DRB Comments

October 6, 2004

**Project # 1002520**

**RE: Villa de la Cueva/final plat**

2894141654
6154951
Page: 2 of 2
18/06/2004 01:09P
Bk-2894C Pg-315

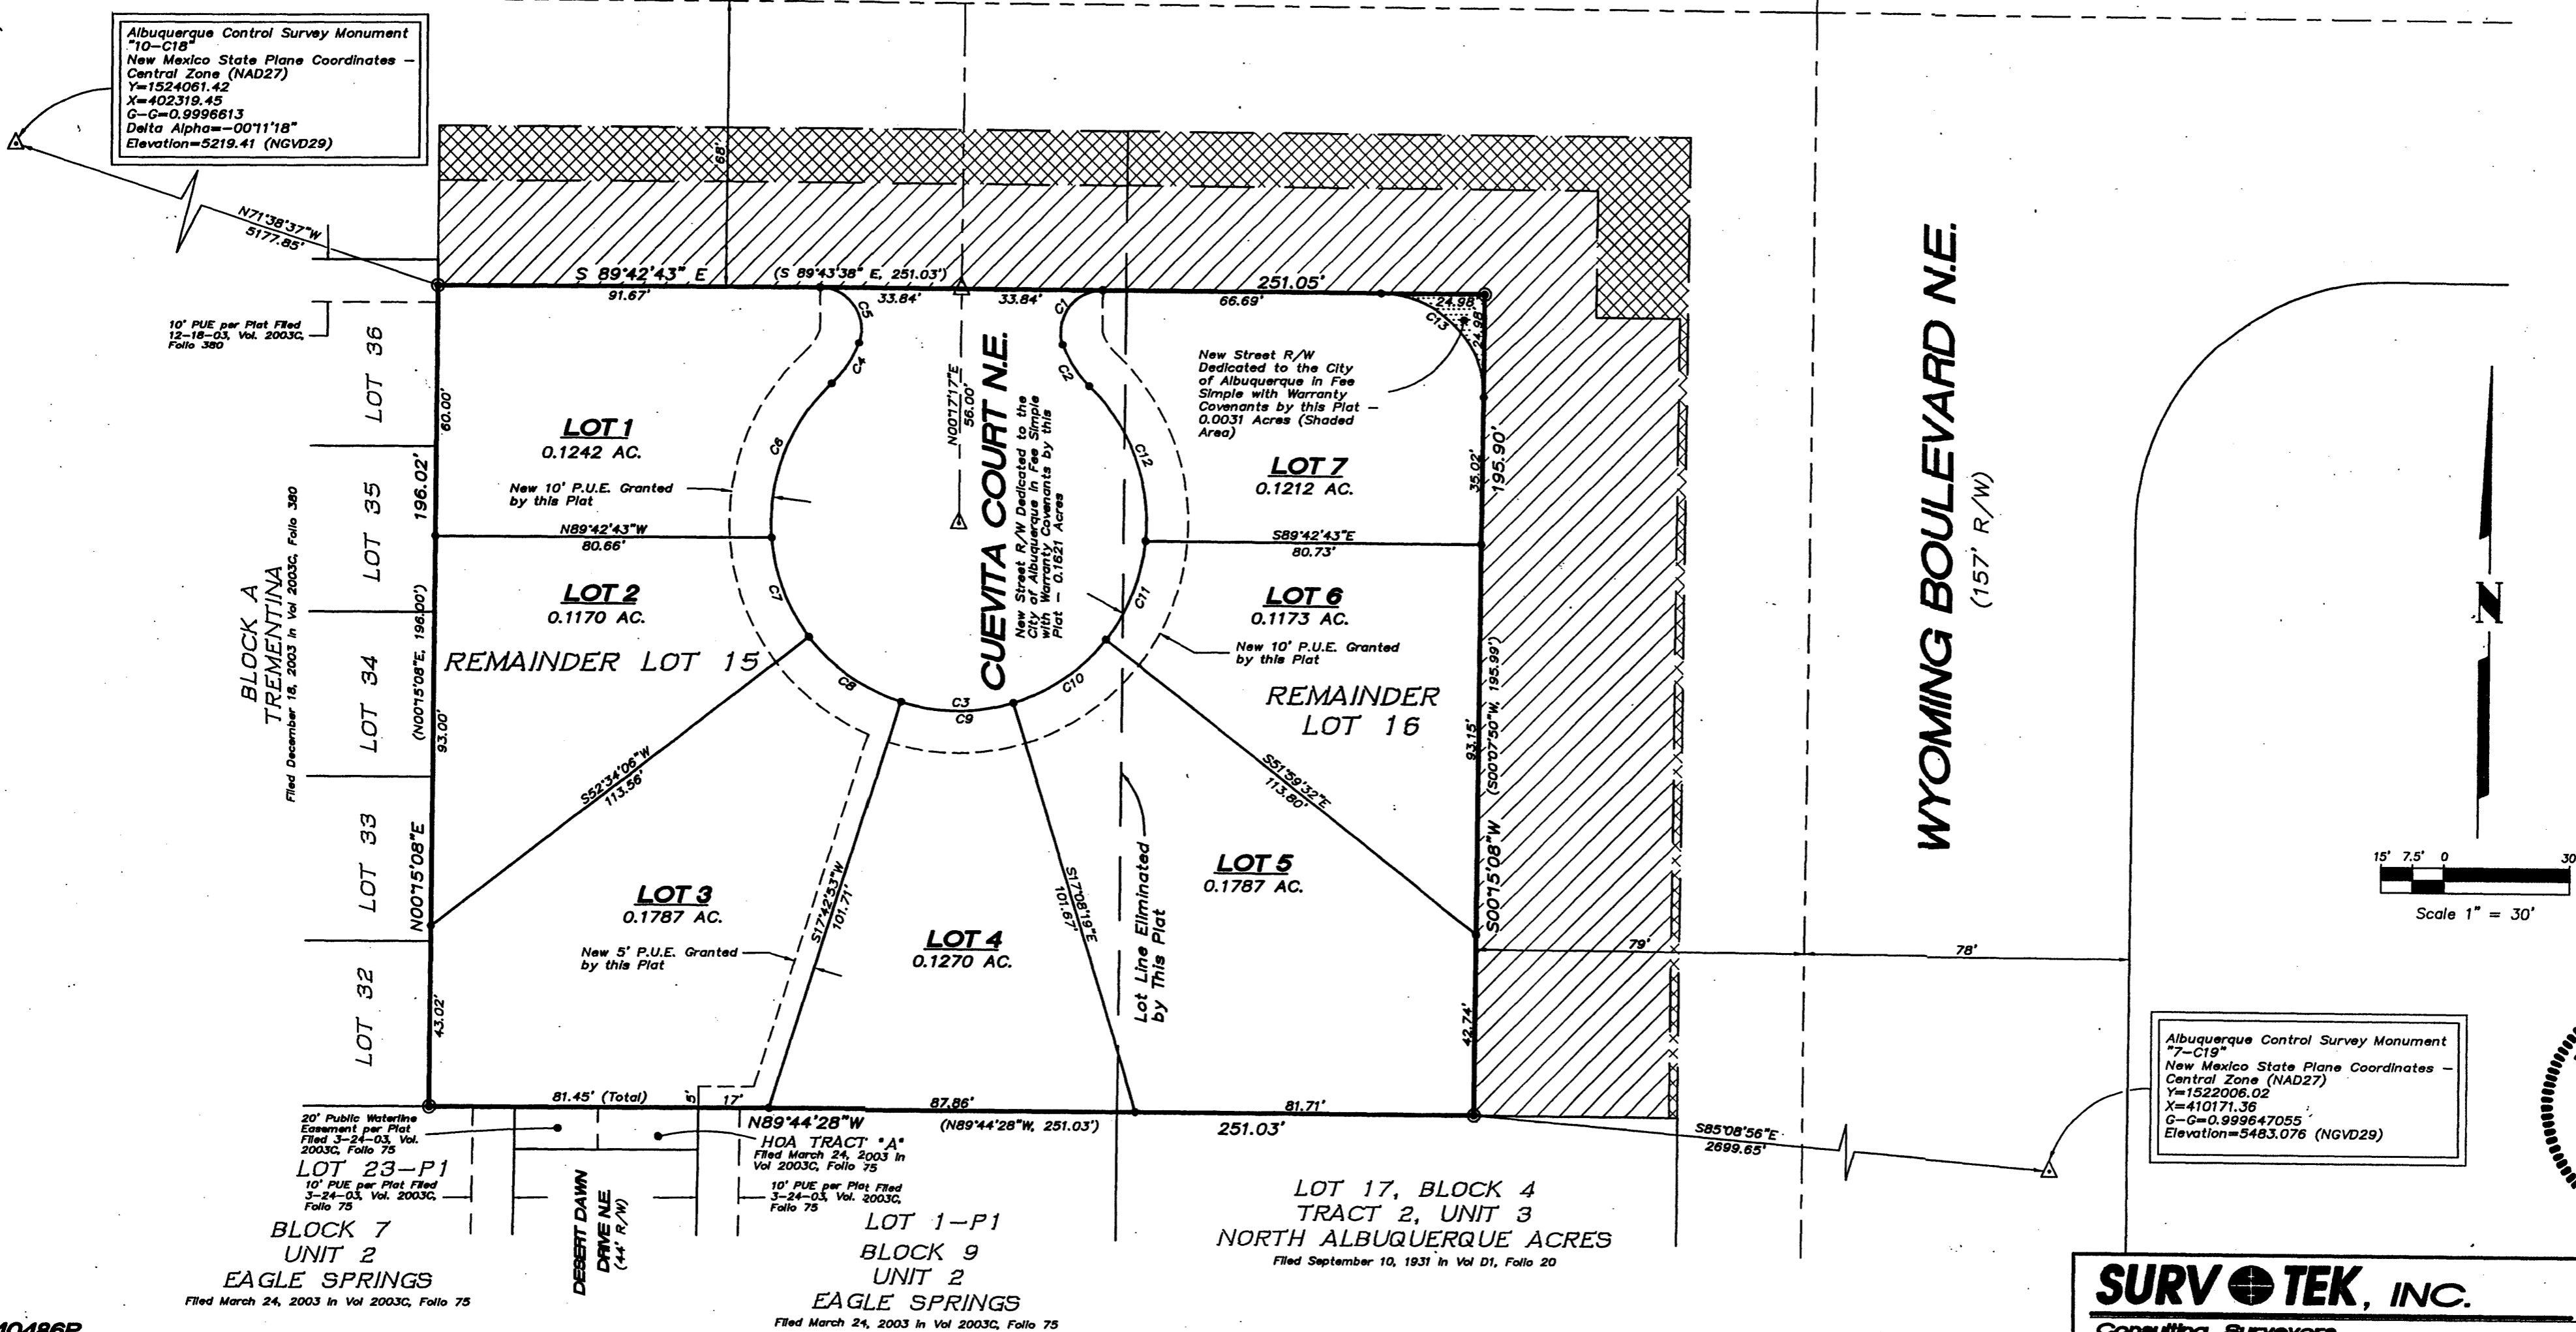
Are there any changes between the preliminary plat & the final plat?

Three conditions of final plat were imposed at the time of preliminary plat approval:

- Cuevita Court must be labeled right in/right out only.
- No direct access to Wyoming or Alameda is allowed.
- Wall design submittal shall be revised to reflect Zone Code requirements.

Are these met?

If so, Planning has no objection to approval of final plat.
